**KIRKLEES METROPOLITAN COUNCIL  
INVESTMENT & REGENERATION SERVICE**

**Reference No:** 2021/65/90386/W

**Site Address:** Wilshaw Village Hall, Wilshaw Road, Meltham,  
Holmfirth, HD9 4DX

**Description:** Listed Building Consent for installation of replacement  
windows (within a Conservation Area)

Drawing 3
Detail of Main hall
Gable end
windows

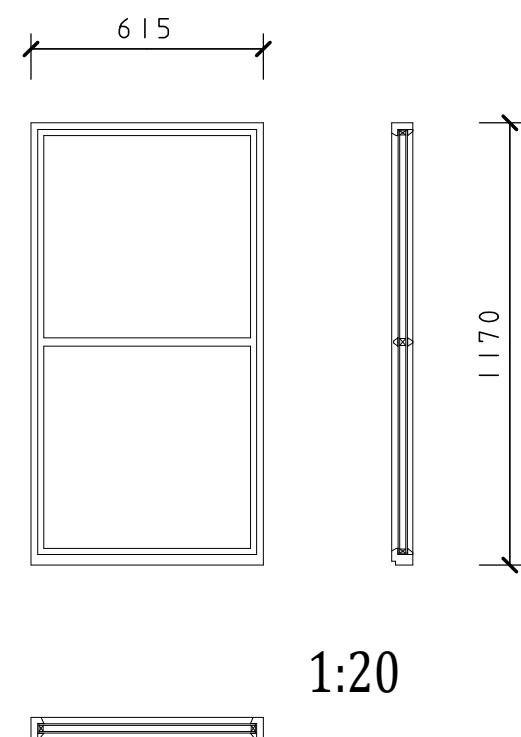
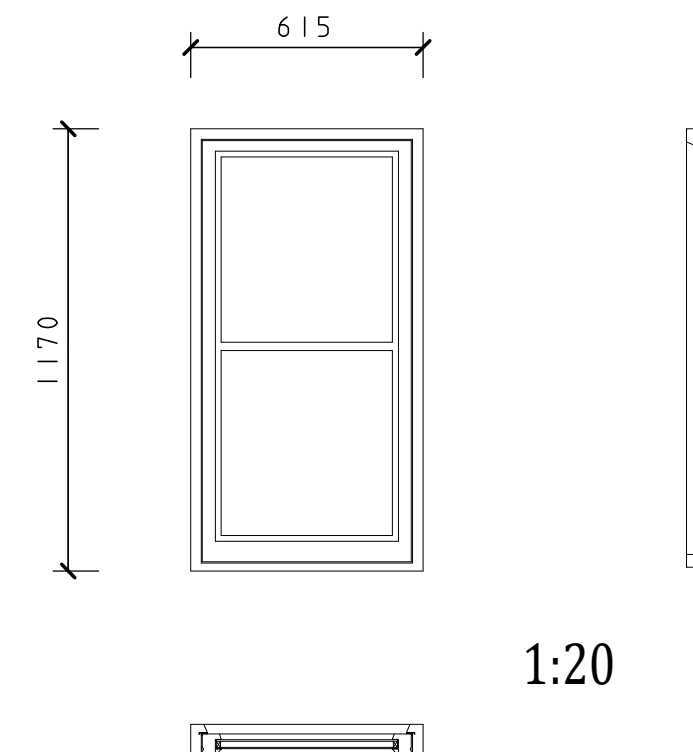
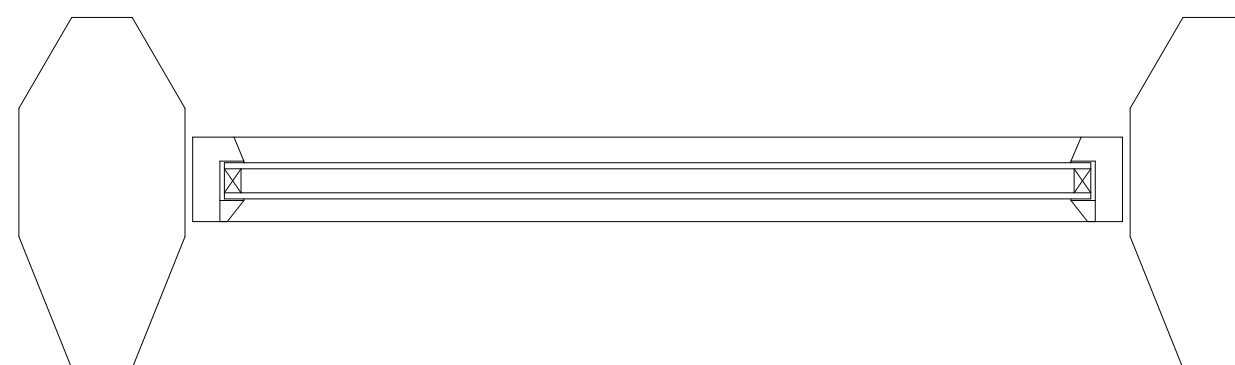
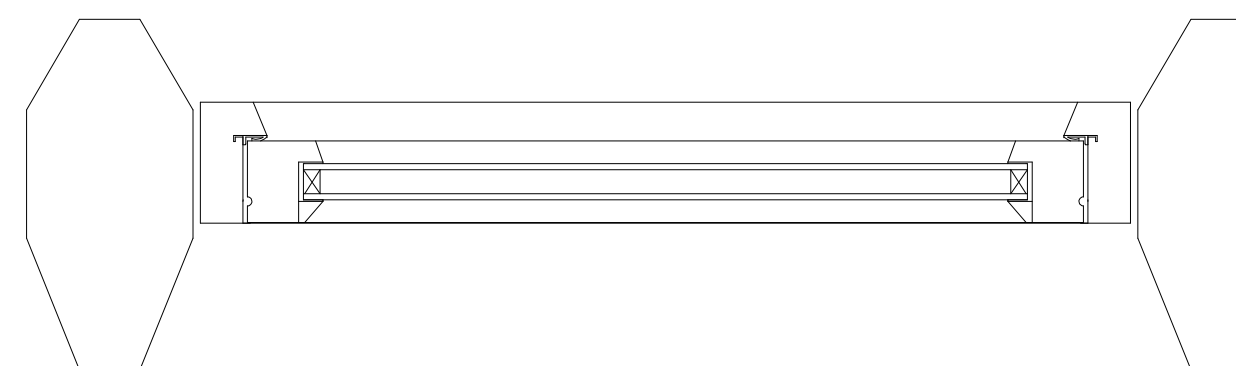
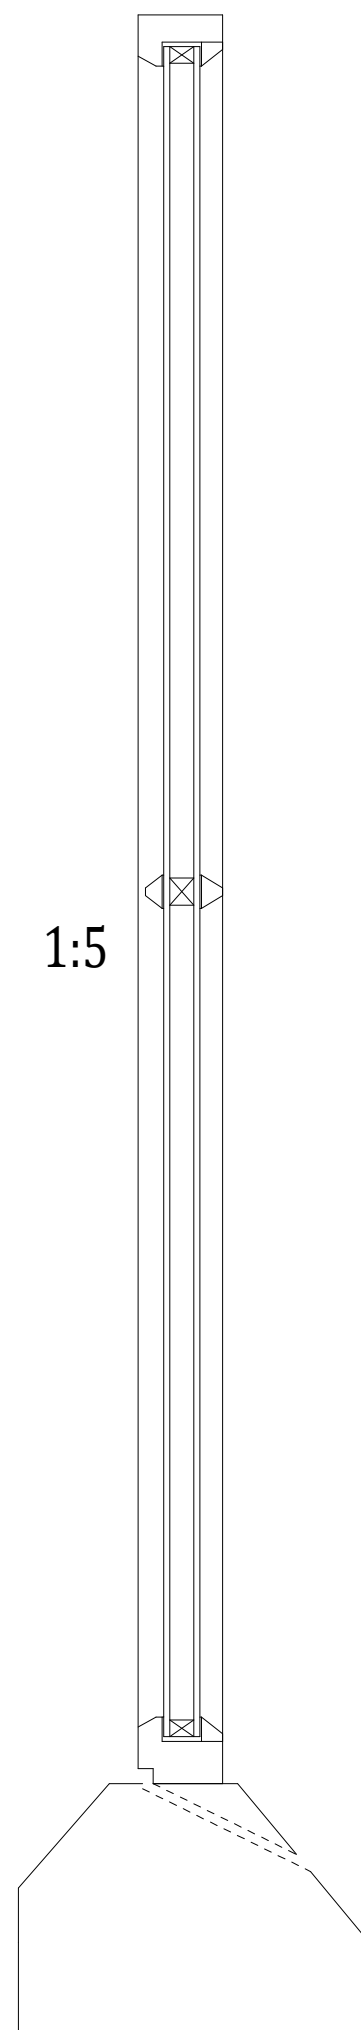
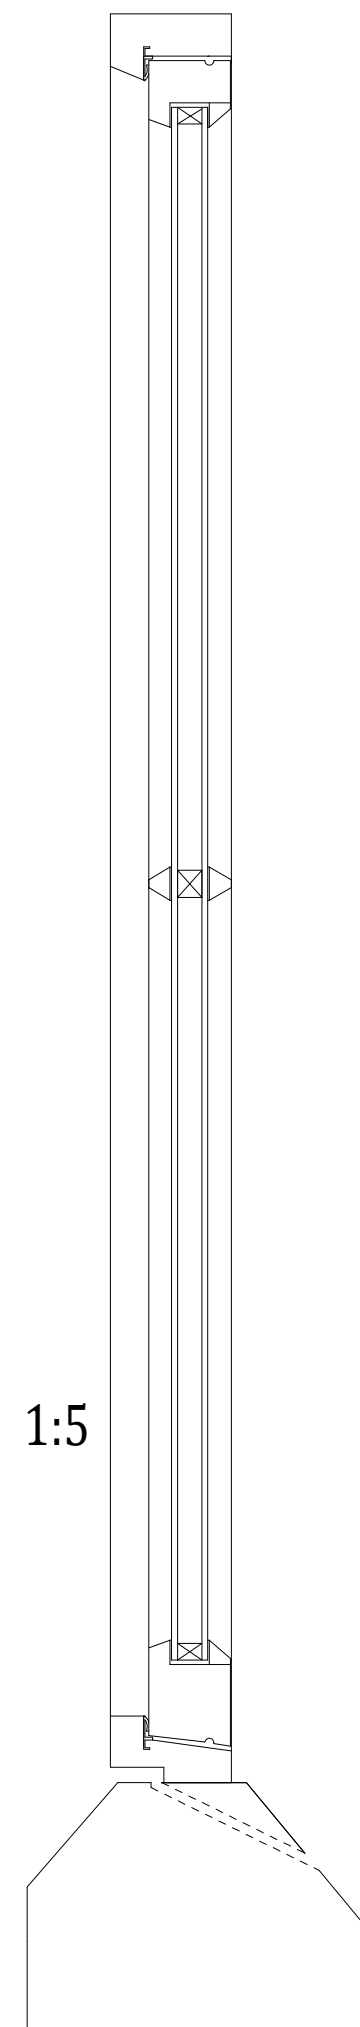
The timber window frames would be significantly thicker than the existing direct glazing with metal framed ventilators. The frames would be 56mm deep for fixed lights and 80mm deep for opening lights. Accommodating frames of such thickness within the existing double chamfered mullions presents aesthetic challenges, as shown in Drawing 2 Section B:B and Drawing 3 (section unnamed) where the frame would project beyond the chamfer on the inside. The alternative would be to move the frame further to the outside, but this would result in the loss of any setback from the chamfered edge externally. The consented lead framed windows would be 33mm for fixed lights and 53mm for opening lights and could be accommodated with less harm to the appearance of the window.

The timber window frames would have significantly wider jambs, heads and bottom rail creating obvious sight lines compared with the existing windows which have no frames (except the ventilators) and are held in place with a narrow putty bead. The frames to fixed lights would be 34mm wide at the jambs and head and 44mm at the bottom rail. The opening lights would be 80mm wide at the jambs, 75mm at the heads and 94mm at the bottom rail. This would have a significant visual impact on the appearance of the listed building. The consented lead framed windows would be 25mm in width all around the frame to the fixed lights and 35mm to the opening lights.

Opening lights would be top hung casements to the kitchen and side hung casements to the gable. The majority of the existing original windows to the front and rear elevations have one ventilated light, these are fixed in an inward opening position akin to a hopper style opening light. The existing kitchen has similar modern timber top hung casements similar to the proposed new windows. There are no opening lights to the gable end and no side hung timber casements of any significance within the listed building as whole (including the former school masters house). The proposed timber

windows would significantly alter the pattern of opening lights and introduce side hung casements to the gable end. Neither the applicant, nor the case officer has been able to identify a suitable hopper style window to replicate the design of the existing window system. The consented lead framed windows incorporated top hung metal openers, the placement of which is subject to a planning condition.
